SEA LINK – DEVELOPMENT CONSENT ORDER - PINS REFERENCE
EN020026

Interested Party submission by N Bridges RIBA
June 2025

- 1.1. National Grid Electricity Transmission – Sea Link Application
PINS ref. EN 020026

Document Title: BARE EARTH ZONE OF THEORETICAL VISIBILITY - CONVERTER STATION SITE 1

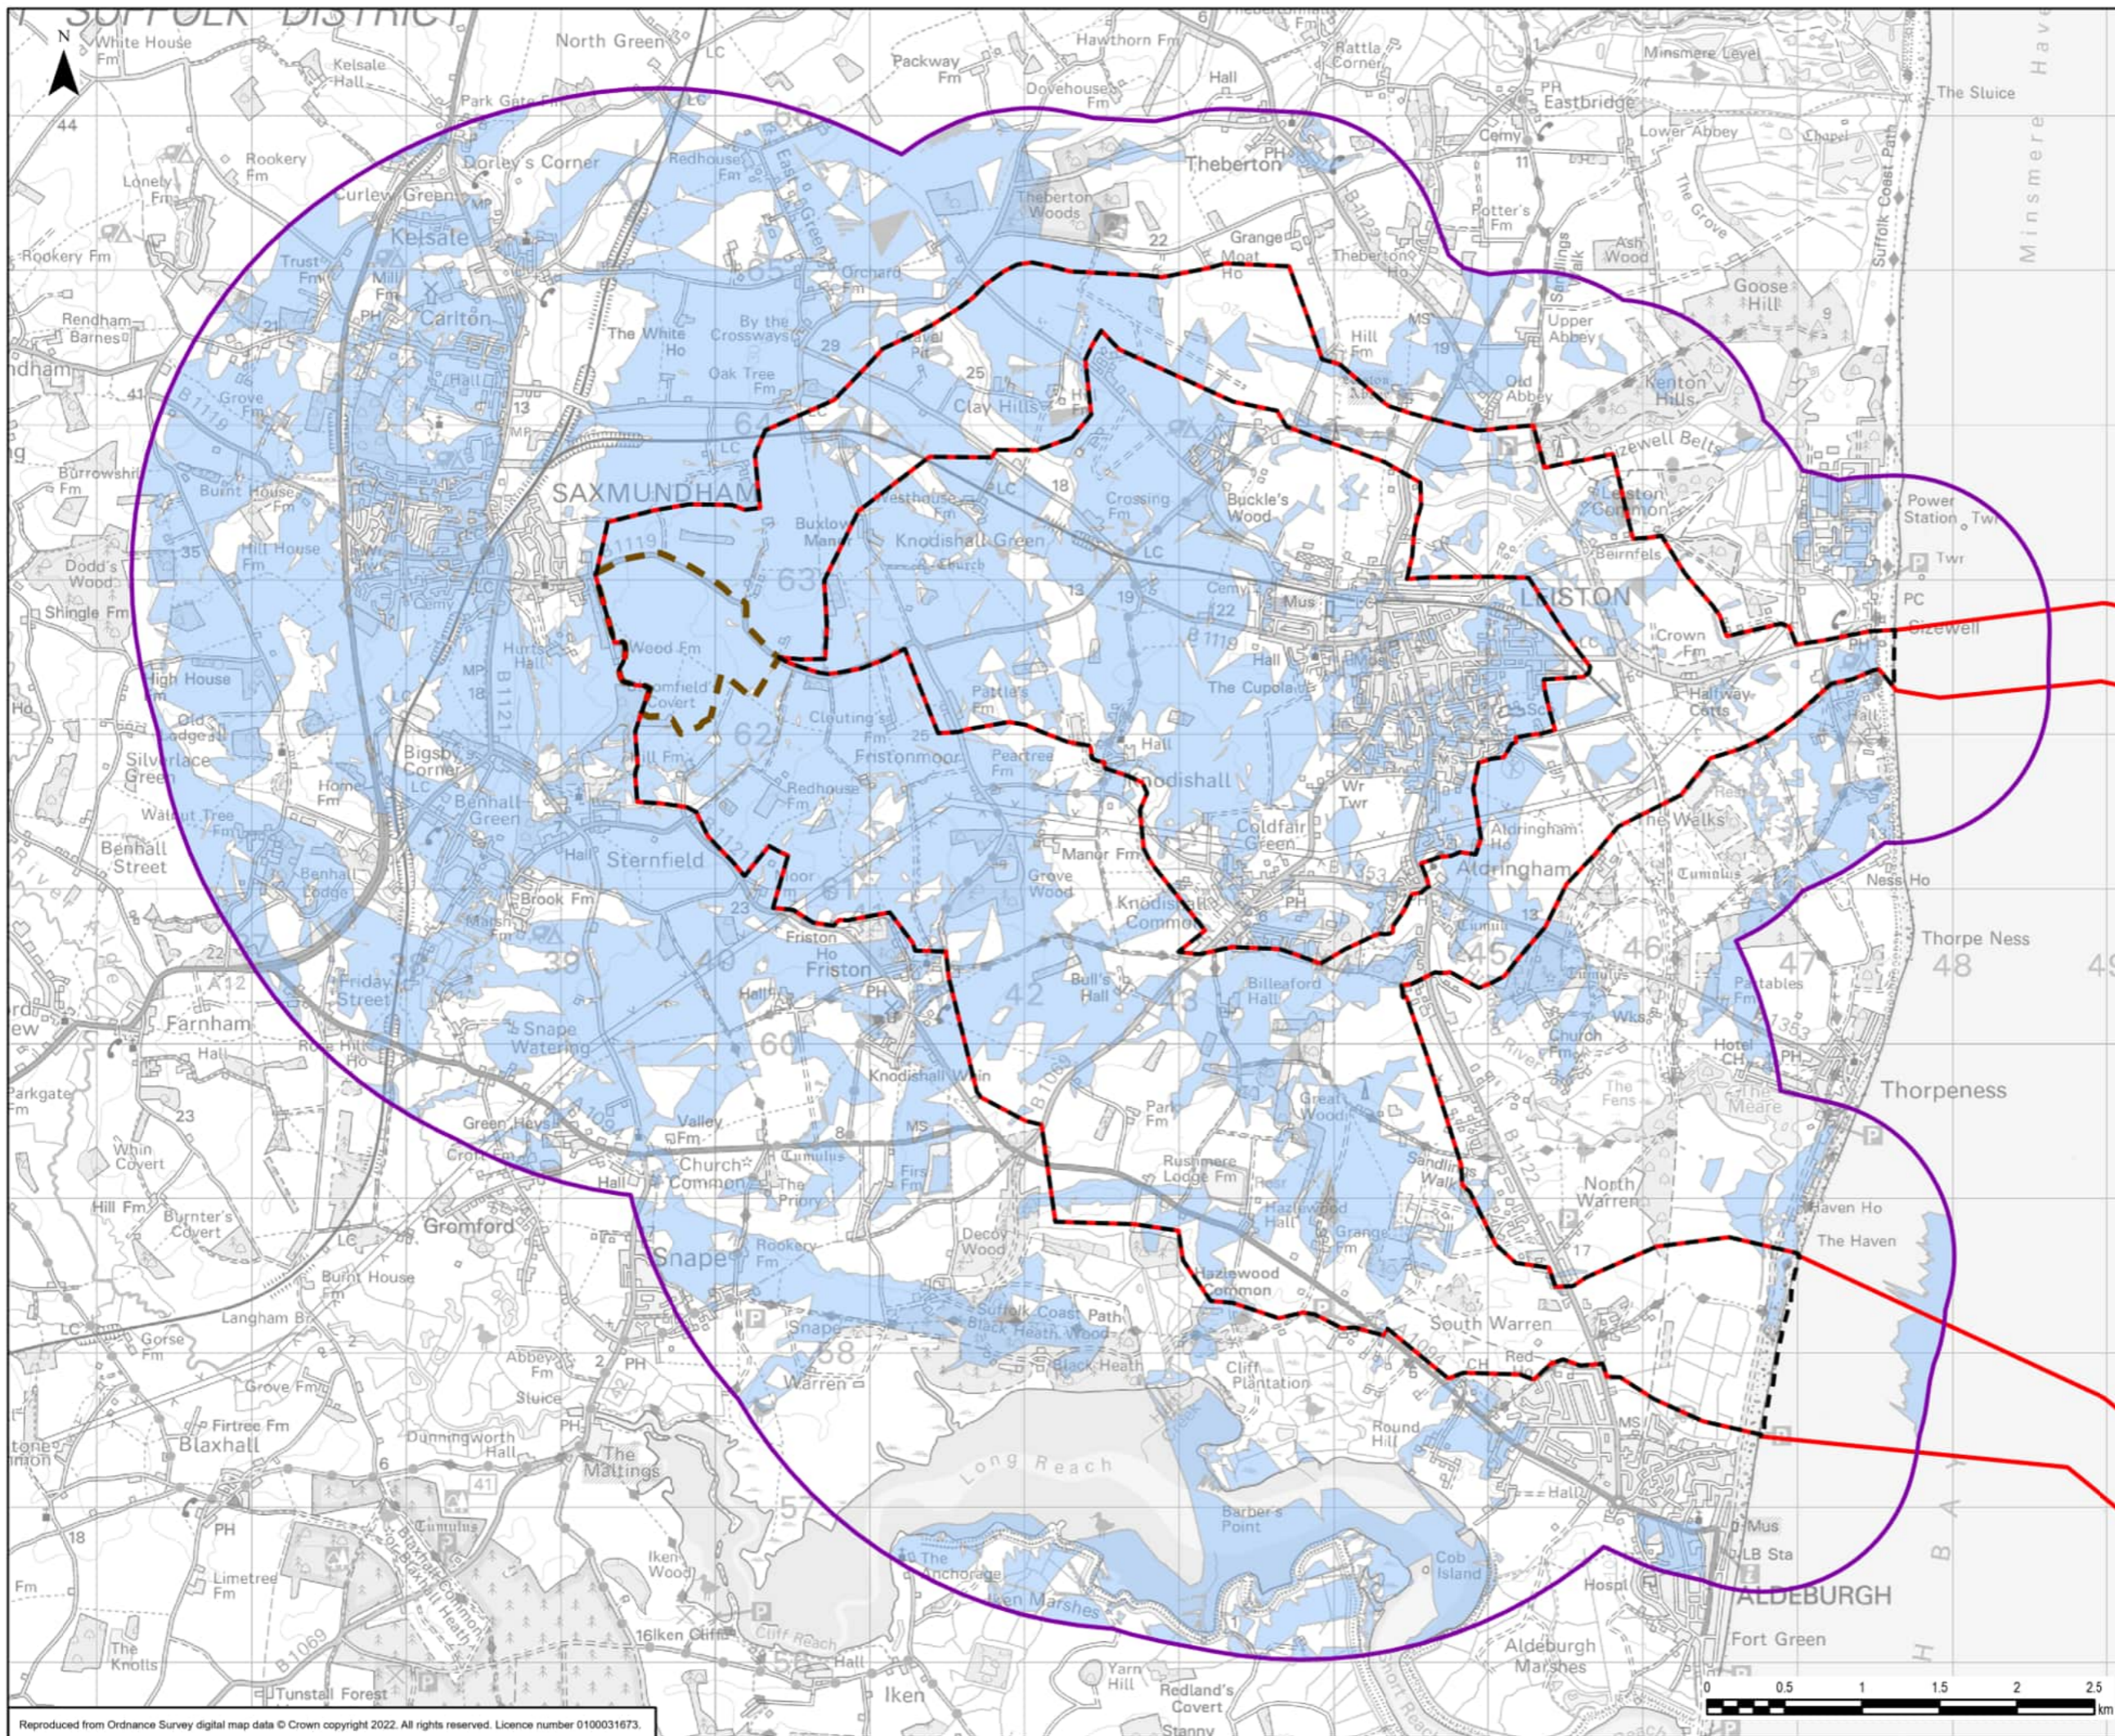
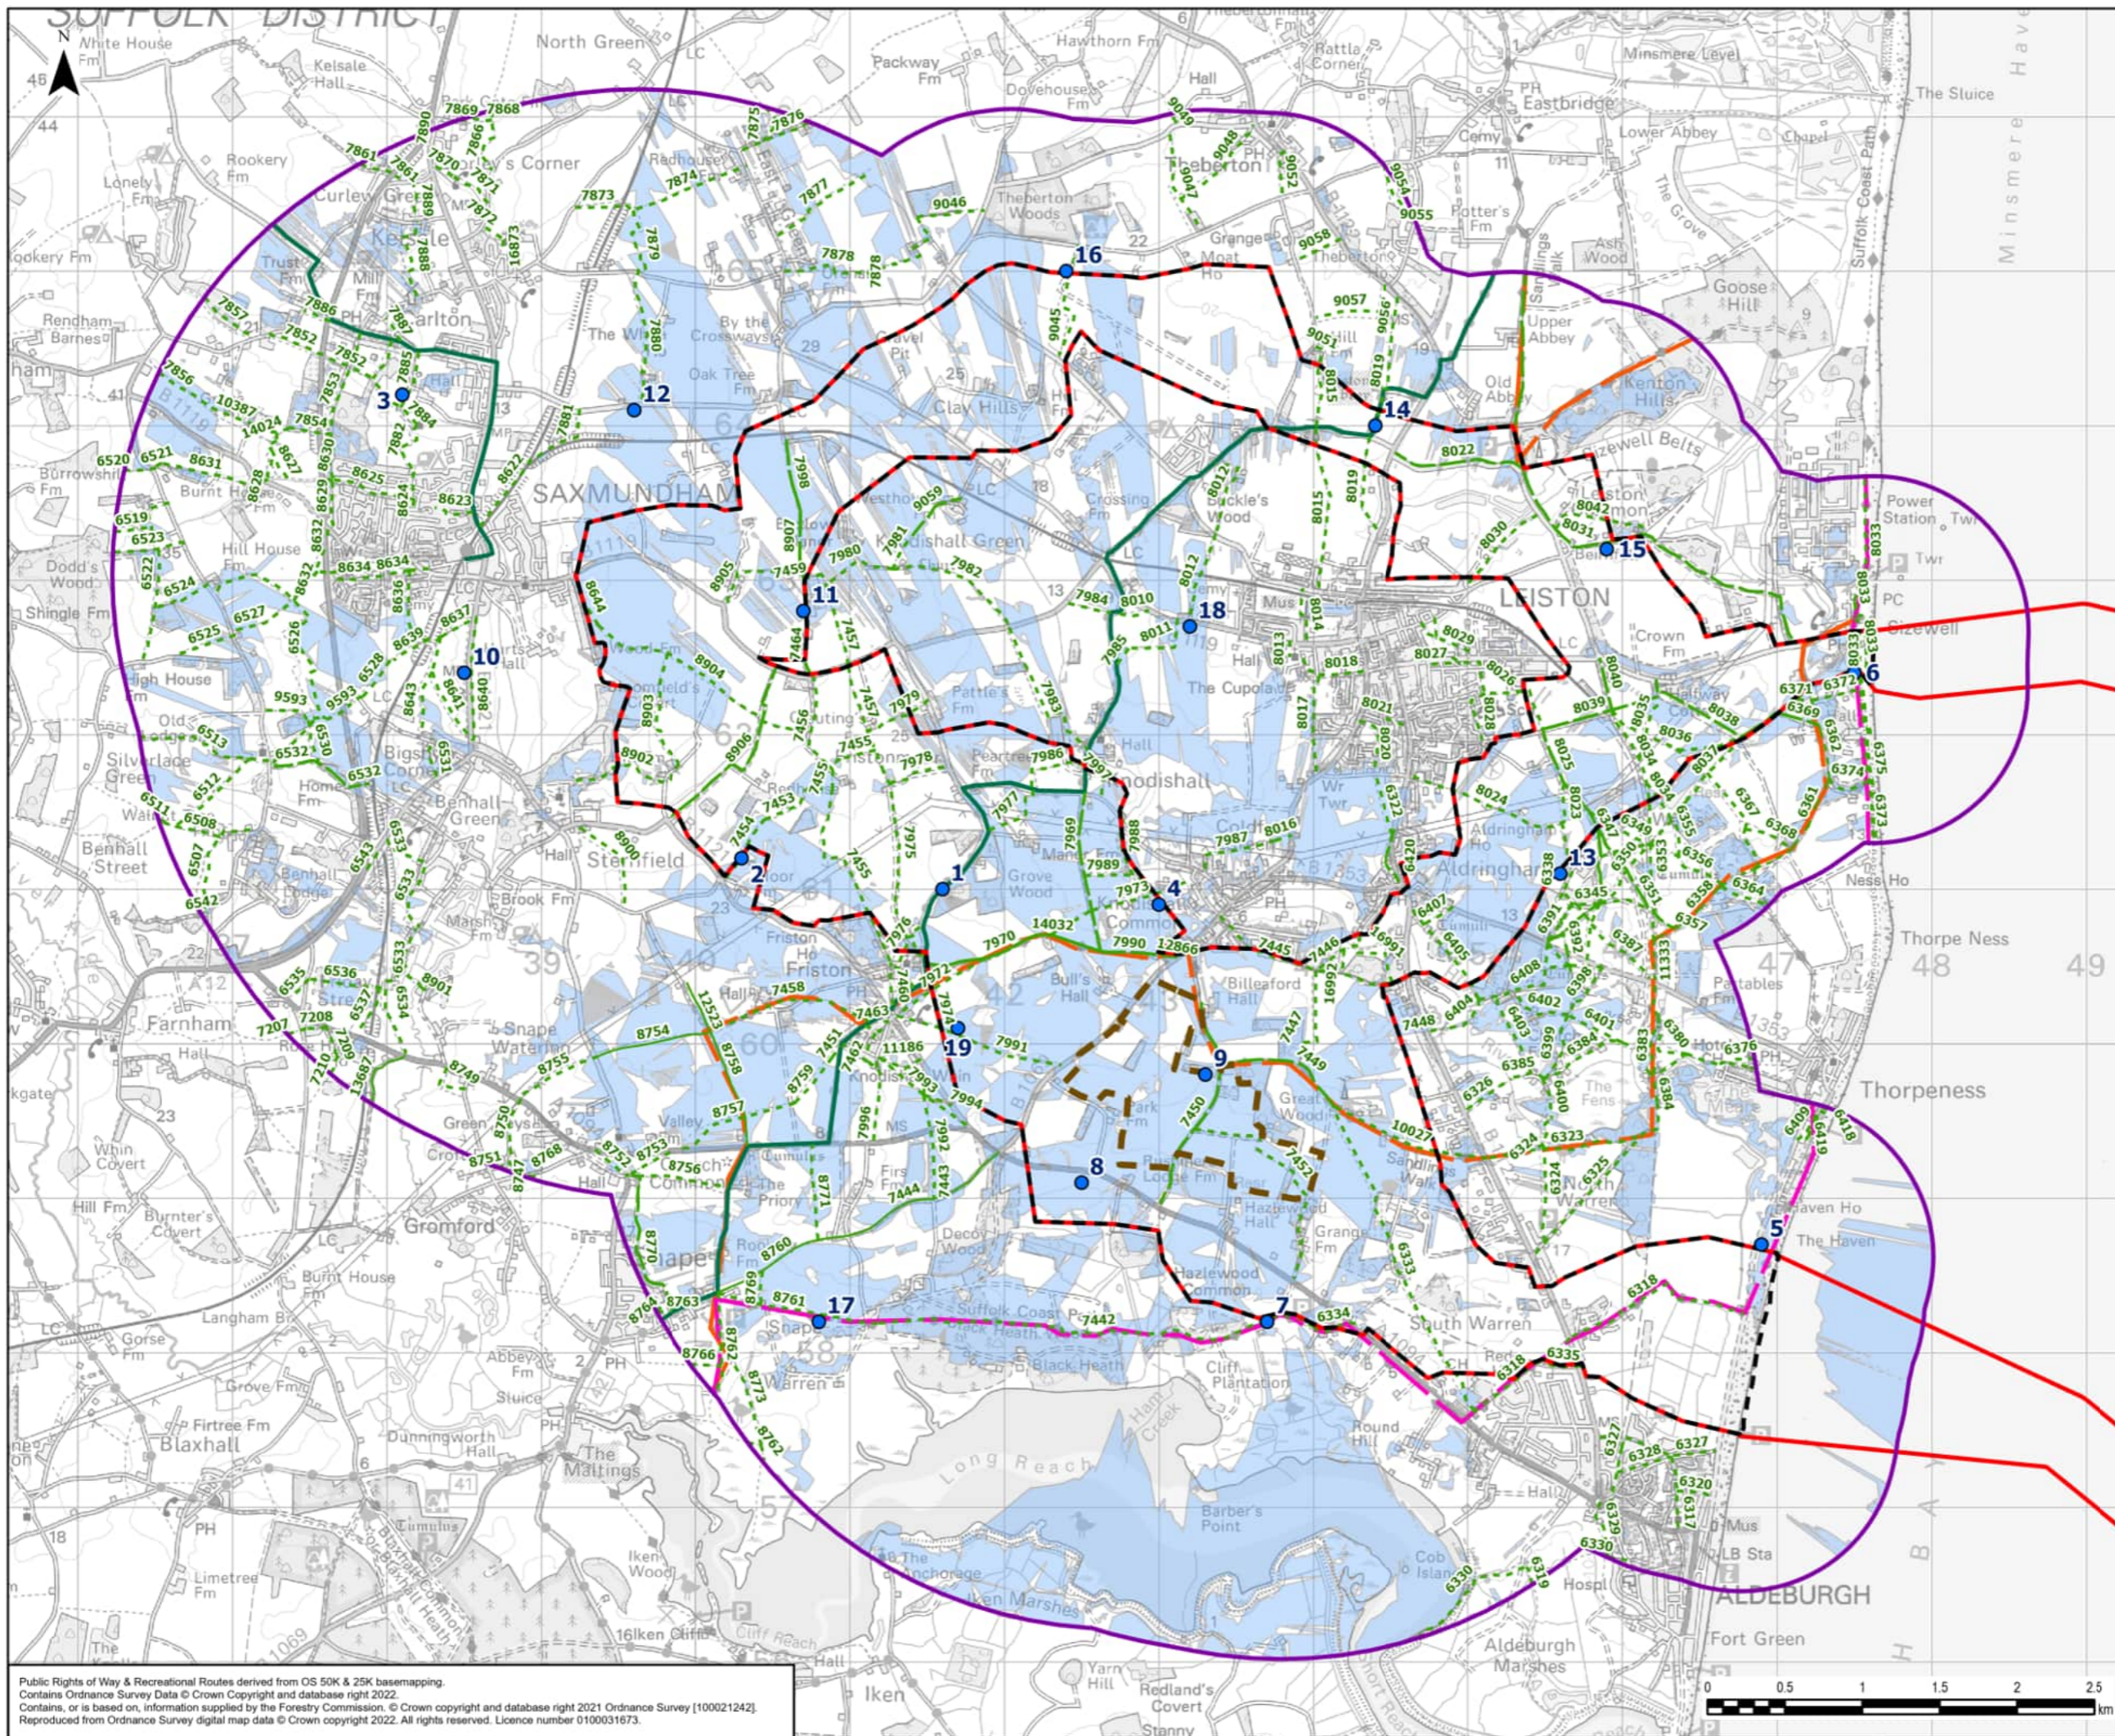
- 3.17. The Area of Search excluded the Alde Estuary, even though the ZTV plans for Cultural Heritage and Landscape & Visual illustrated above show the proposed development would be visible on the south side of the Alde estuary and at Slaughden. The estuary is covered by multiple policies: AONB, Heritage Coast, Ramsar, SSSI, SPA. Protection by multiple policies of nature and wildlife has allowed invertebrates to thrive in the intertidal mud flats upon which birds forage. The Blyth, Alde and Ore, Deben, Orwell, and Stour estuaries in the SC&H AONB are the locations of some of England's finest wildlife habitats, intertidal areas of mudflats and saltmarsh [**Suffolk & Essex Coasts and Heaths AONB Management Plan, 2023-2028, p14**]. The Alde estuary is unusual and special for the conglomeration of receptors which contribute to a sense of a place with very high values. The Scoping Opinion advised that "heritage specific viewpoints should be produced to support the heritage assessment. Suitable cross-referencing between the LVIA aspect chapter and Cultural Heritage aspect chapter should be included." [**6.14 – 3.1.11**].

- 3.26. The ExA is requested to ask NGET to include a proper assessment the Alde estuary in the Cultural Heritage and Landscape and Visual chapters of the ES. The model used to generate the ZTV plans should be run again further south to include the southern side of the Alde estuary, down to Tunstall Road on the ridge.
